Re: Triton Quick Mart #EHFL2304-0001
205 E Jackson St
Erwin, NC 28339

The plans and specifications for the Triton Quick Mart have been reviewed and are disapproved for the following reasons:

PROPOSED FLOOR PLAN
TRITON QUICK MART
 205 E. JACKSON BLVD.
 ERWIN, NC 28339

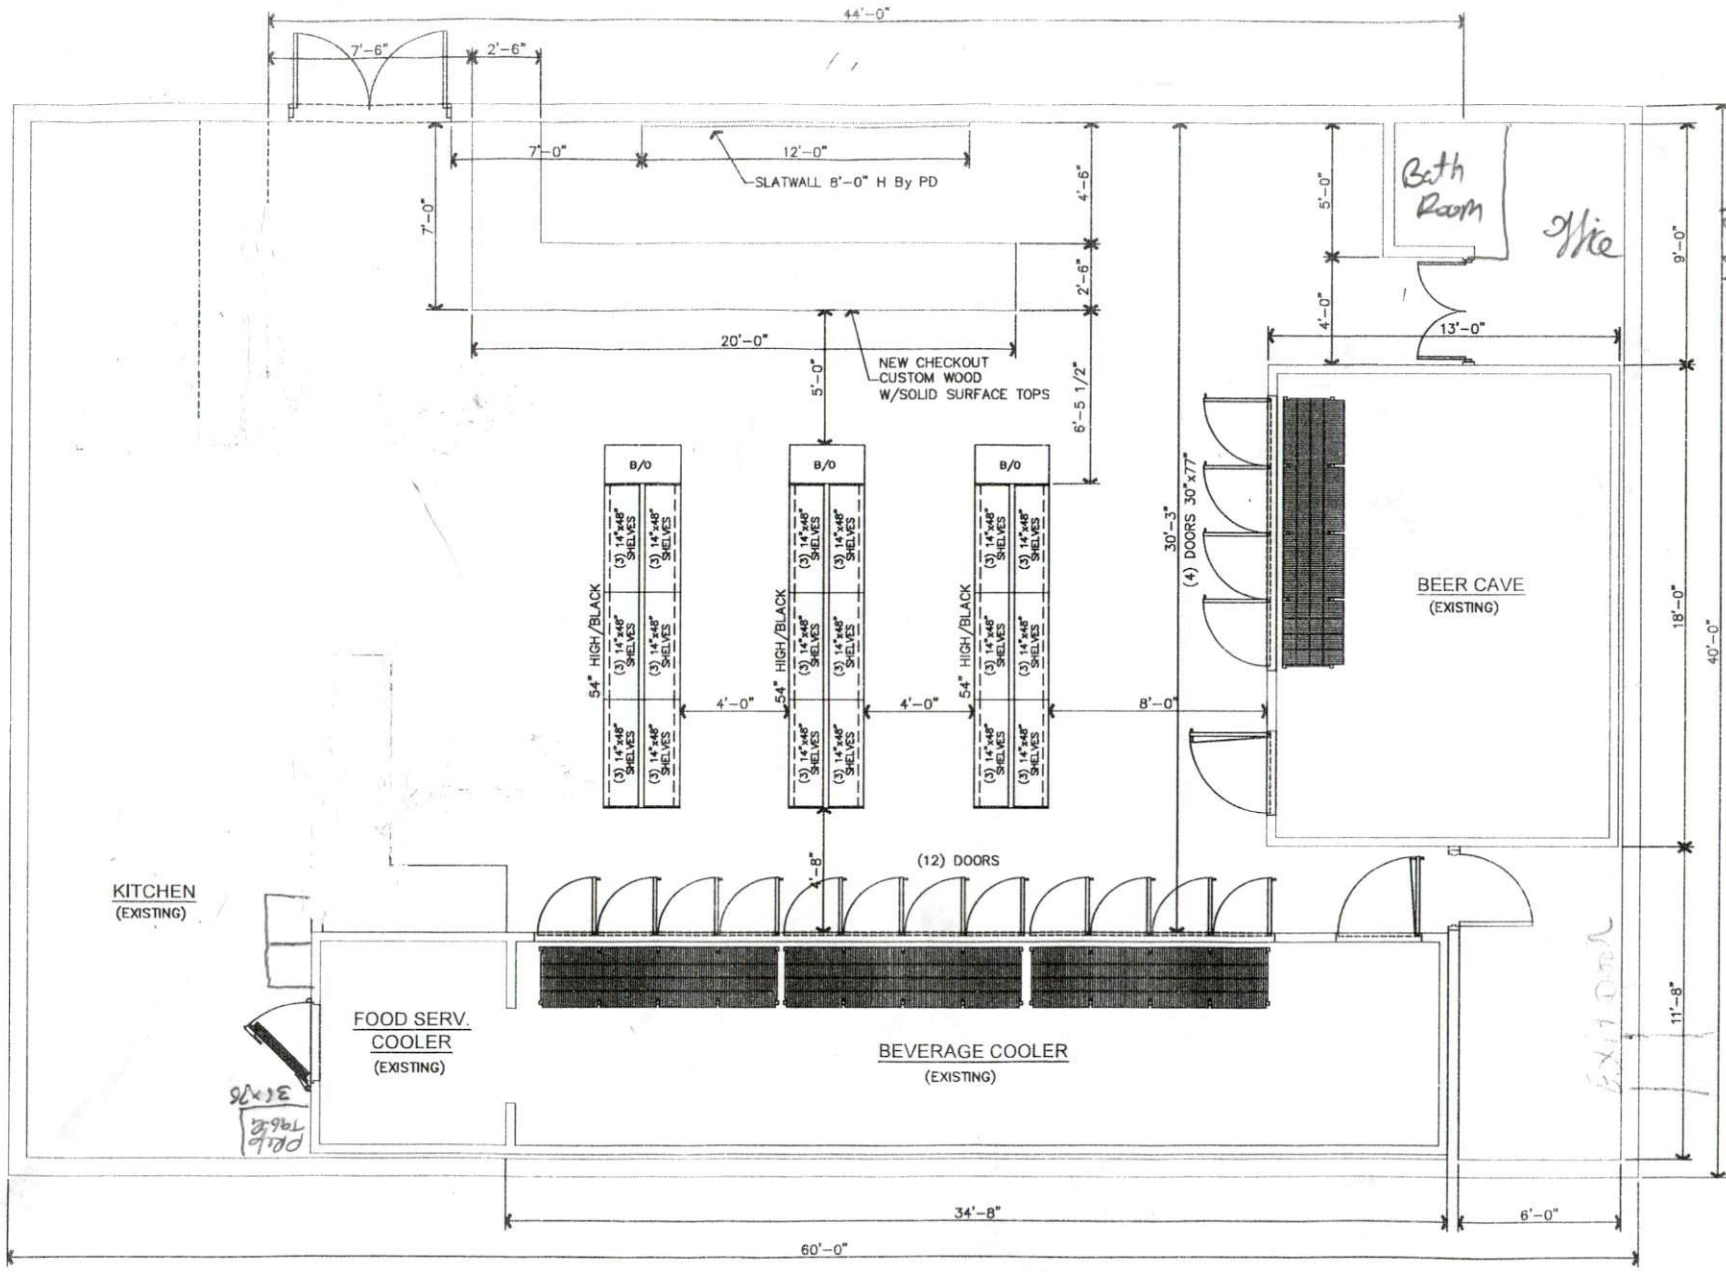
- 1-The food service application is incomplete.
- 2-The site plan is not to scale as requested. All equipment including shelving, dry good storage, bathroom, dumpster and grease receptacle must be shown on the site plan.
- 3-Equipment specification sheets are missing and make and model was not indicated on specification sheets provided.
- 4-The menu must have all foods listed that you intend to offer for sale. This includes condiments, such as lettuce, tomato, pickles, etc., for sandwiches.
- 5-Food process sheets must be filled out for each menu item and the questions on the food process sheet must be filled out in detail for each menu item.
